23 January 2015

RESPONSE TO NOTICE OF Modification to SSD 6076 (MOD 1) 4 Murray Rose Av, SYDNEY OLYMPIC PARK

Dat Tran
A/Manager, Planning

4 Murray Rose Landscape Plan

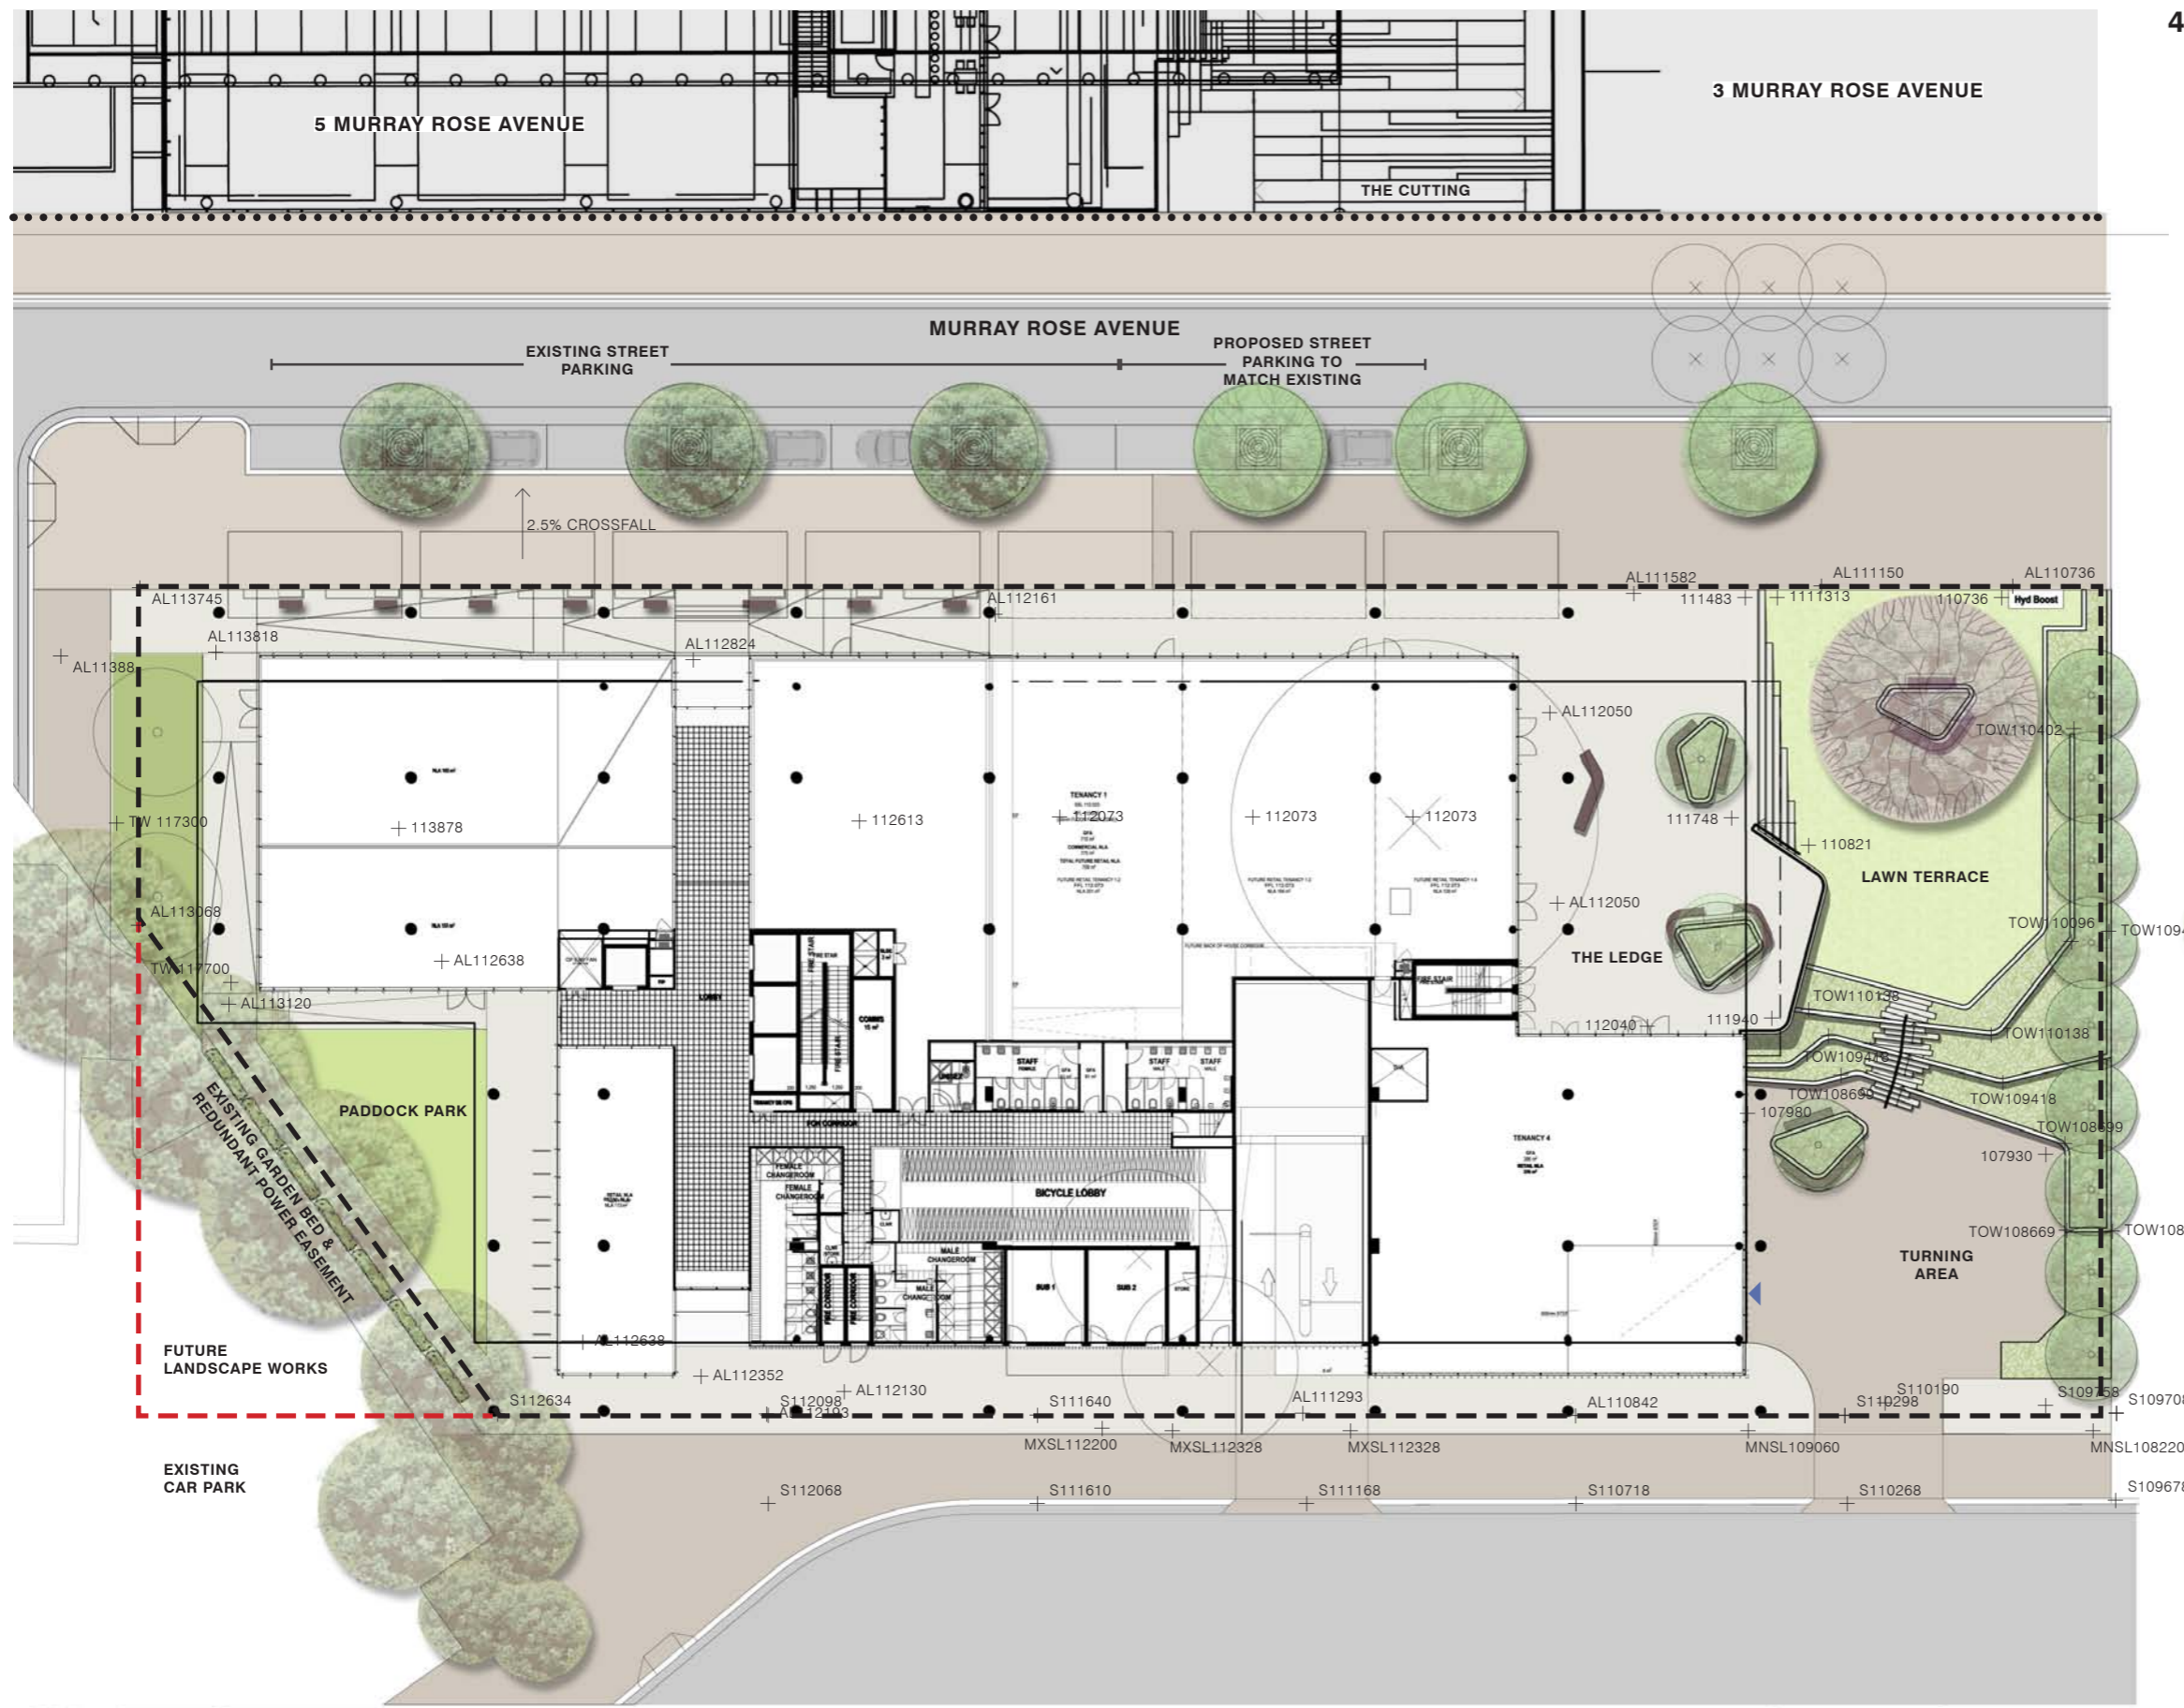
The external paving crossfall varies significantly along the Dawn Fraser Avenue (DFA) frontage (from 1in 30 to 1in170). Apart from difficulties in walking along an excessively undulating surface, the external pavement will have an uneven appearance and may have areas of ponding. the proposed levels on DFA will need to be resolved in greater detail to ensure smoother and more consistent gradient transitions and it is recommended that the proponent's consultants liaise directly with SOPA to address this issue.

Landscape drawings are showing a different finish to 'building skirt and colonnades'. The pavement finishes within the building boundary should be trihex paving to match both the MRA and DFA frontages. Note that a consistent pavement finish from the kerb to the building line is normal practice at SOP (even if the building line is setback from the site boundary e.g. the CBA buildings at 2 and 4 Dawn Fraser Ave).

Drawing Title
THE LEDGE
DETAIL PLAN

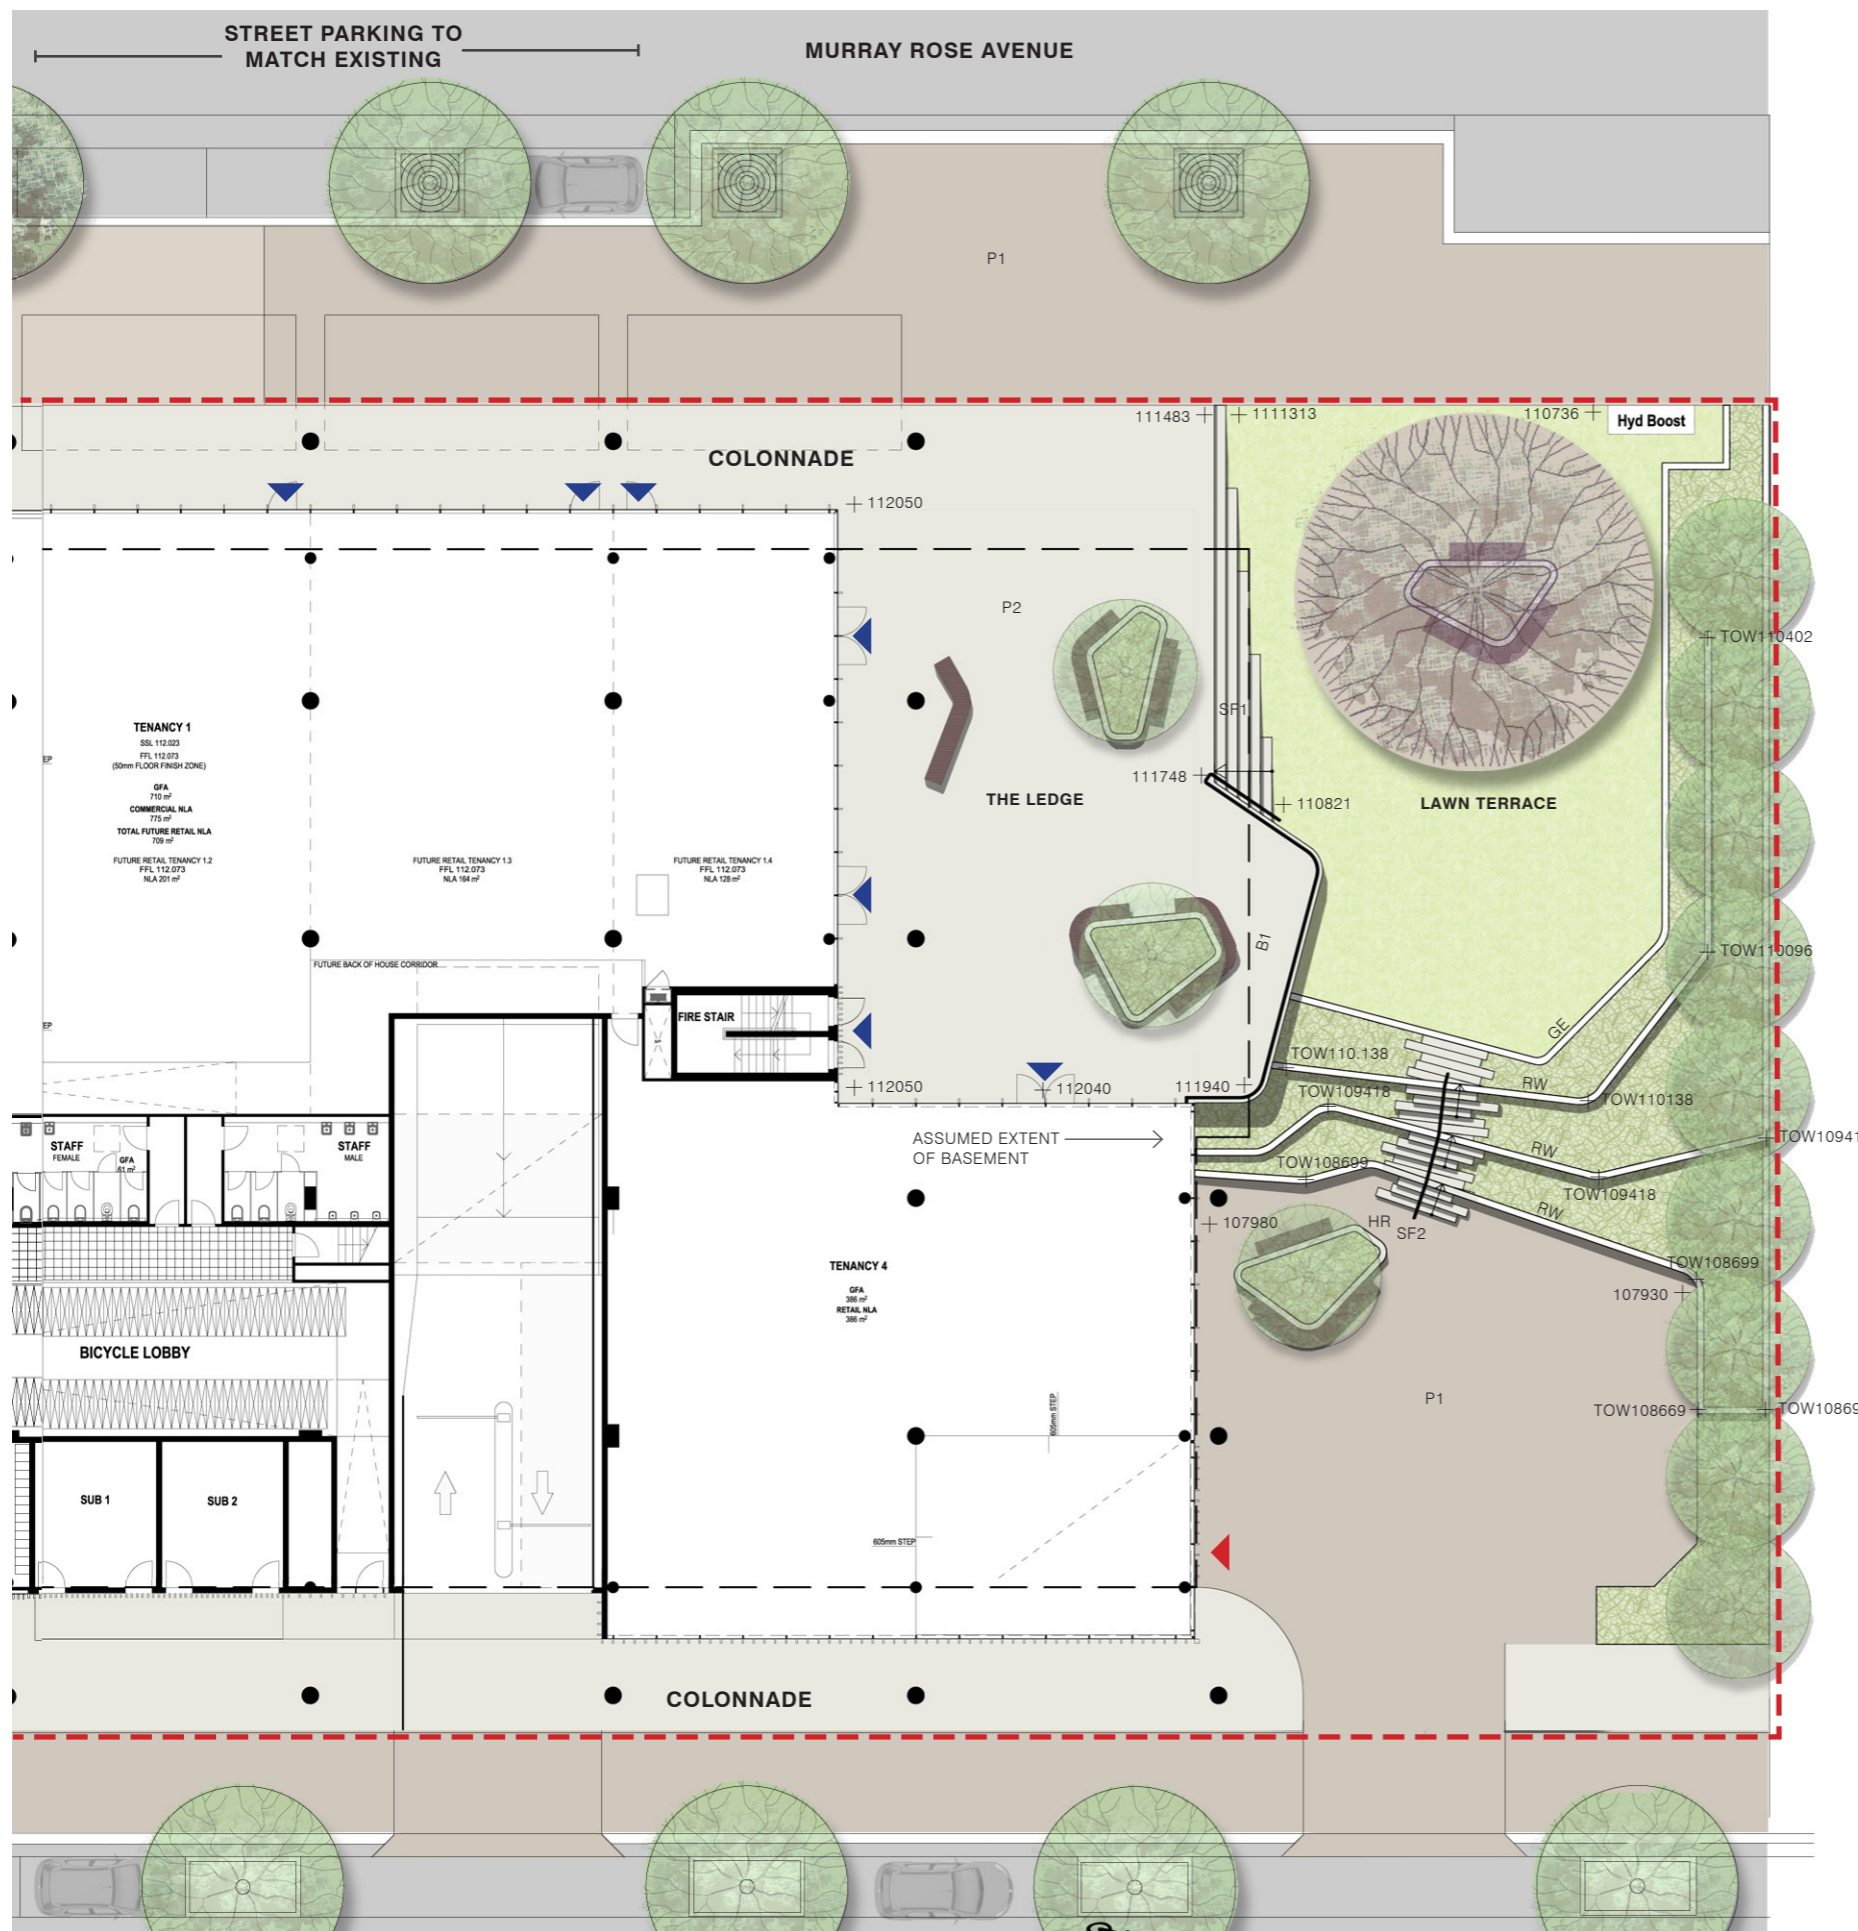
The revised public domain drawing (TURF -LA3 Rev E), shows a stepped pedestrian link connecting a 'Lawn Terrace' and open paved area 'The Ledge' with the proposed loading dock. This revision doesn't resolve the potential conflict and safety issues for pedestrians in close proximity to delivery vehicle movements associated with the loading dock and results in the loss of an accessible through-site pedestrian link.

Recommendation: That GPT reinstate (as shown in earlier GPT design proposals and in accordance with MASTERPLAN 2030, Precinct Controls p.163), a through-site link (ideally ramped) to provide a safer and more direct pedestrian connection between the Dawn Fraser Ave to Murray Rose Ave footpath and Brickpit Park, through 3-5 MR Ave. This link should utilise the 3m wide landscape corridor shown along the eastern site boundary which is shown offset from HV and sewer zones (TURNER Drawing EA104 Rev X).
